East Preston Parish Council
Mr Simon Cross
Council Office
122 Sea Road
East Preston
BN16 1NN

Front extension to form attached double garage.
14 Tamarisk Way East Preston

Thank you for your internet comments made on 8th April 2015 which has been recorded as 'an objection' with the comments as follows:

Roof Plan as Proposed

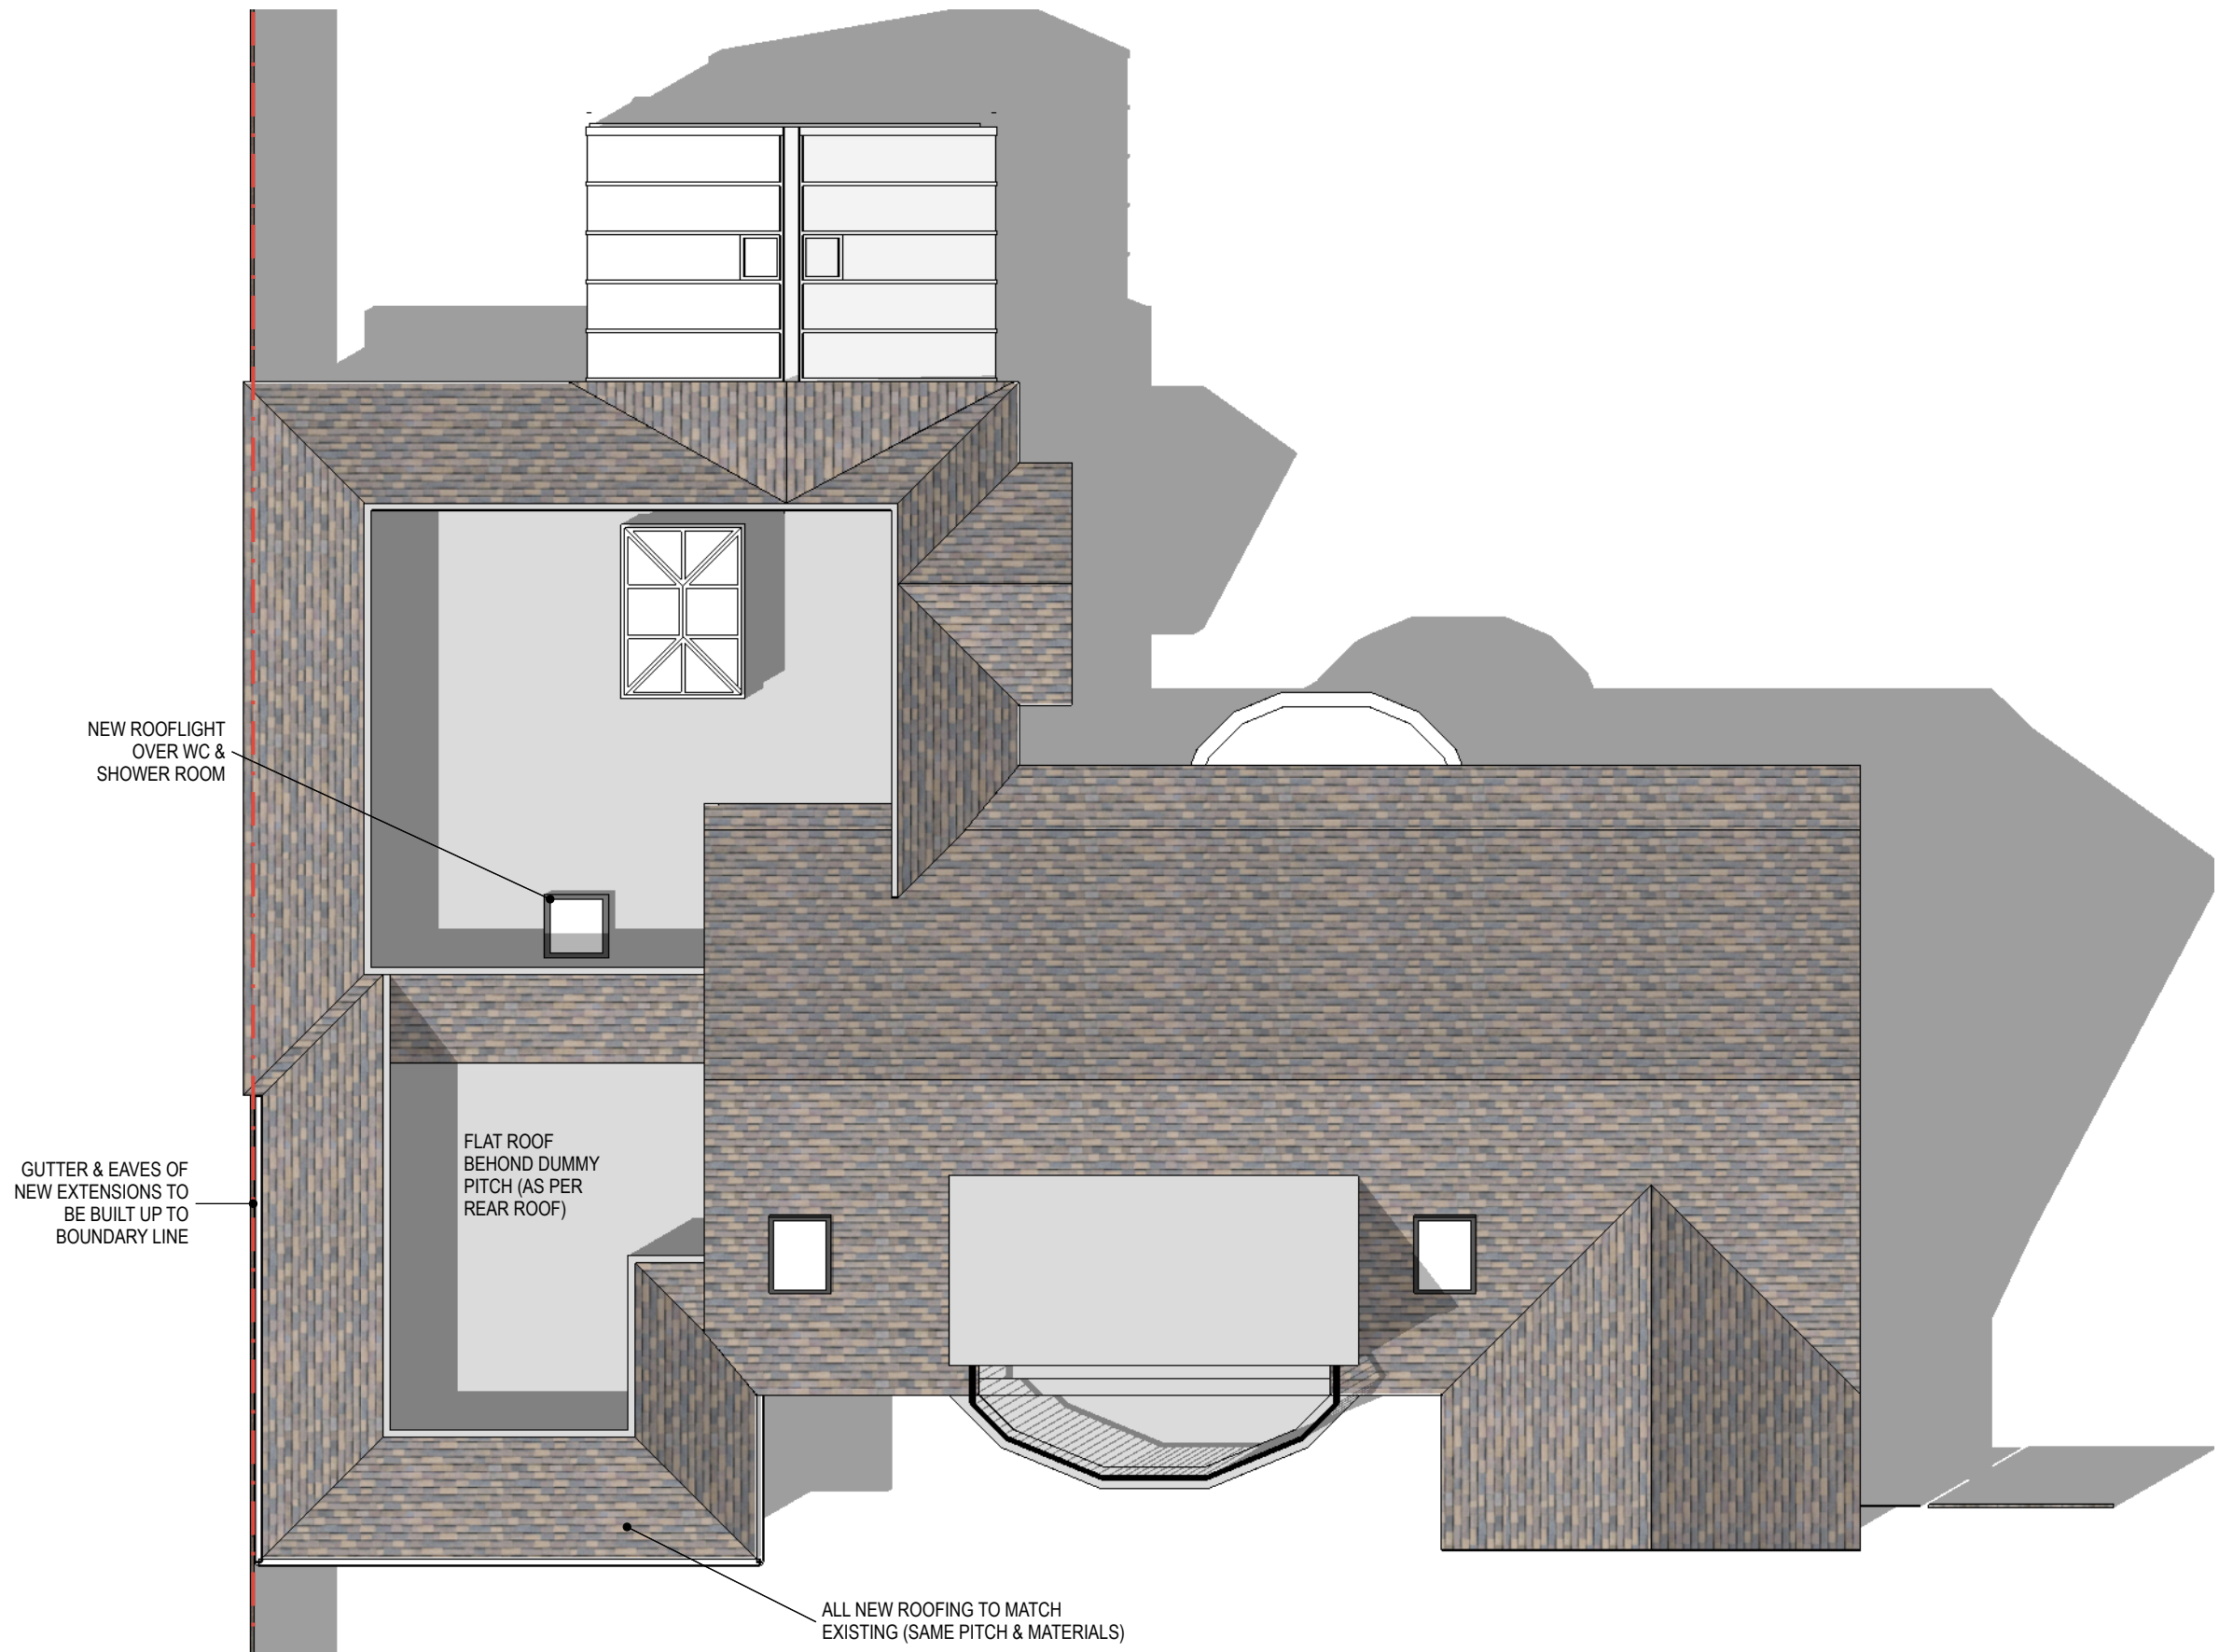
Because of its height, length and mass and because it is being built closely adjacent to the western boundary, the proposed extension will have an unacceptable harmful overshadowing and overbearing effect on No. 16 Tamarisk Way in conflict with policies GEN7(iv) and DEV19(iii) of the Arun District Local Plan and policy D DM4 of the Emerging Local Plan.

Government advises local planning authorities new developments should respect local character and appearance. This council feels the proposed extension built on the boundary for a significant depth would detract from the open plan feel of the Willowhayne estate. The council feels this is contrary to policies D SP1 and D DM4 in the emerging Local Plan and to saved policy DEV19 in the 2003 Local Plan. The property in question is covered by Policy 2: Design in Character Area One of the East Preston Neighbourhood Plan which states [t]he existing street scene should be protected the council feels this proposal would have a negative impact on the existing street scene.

DRAWING TITLE:
South & West Elevations plus Sections
AA & BB as Proposed

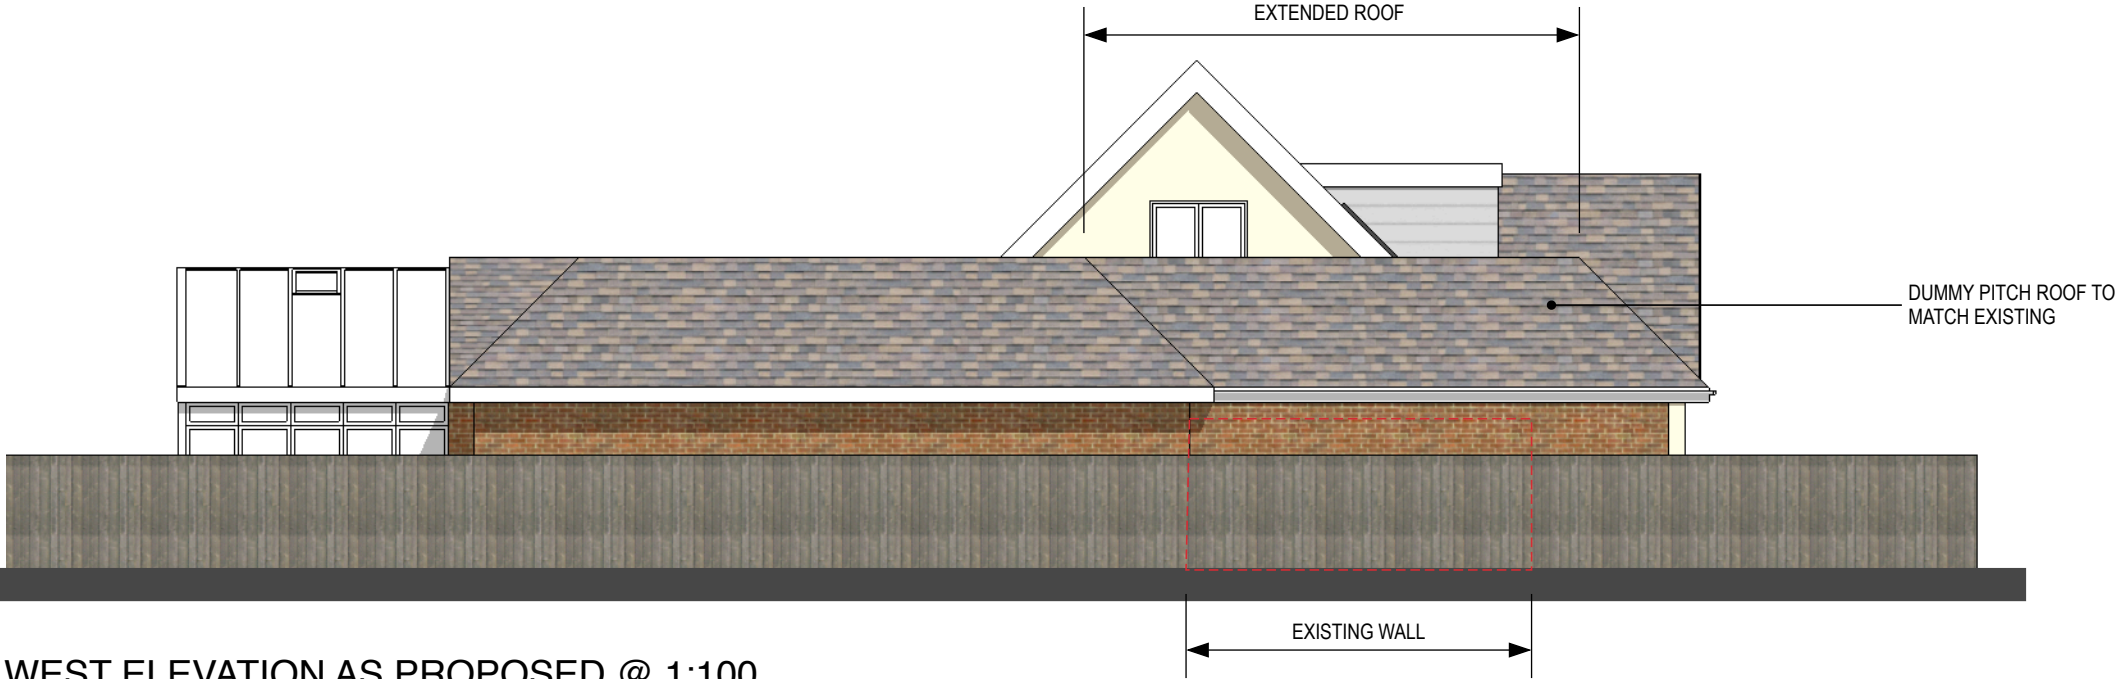
There is already a relatively close spatial relationship between nos 14 and 16 Tamarisk Way, and this proposal will further erode what space there is on the western boundary. Within this spatial context, the dimensions and location of the proposed front extension are likely to have an unacceptable detrimental impact upon the residents of no 16.

The proposed development compromises the spatial character and pattern of the street and would have an unacceptable impact on the appearance and setting of the area generally. The proposed development would also have an adverse overbearing impact upon no 16 Tamarisk Way, as it is being built on the boundary for a significant depth. This

The proposal leaves too little space on the western boundary for the owners of no 16 to soften its impact in any way.
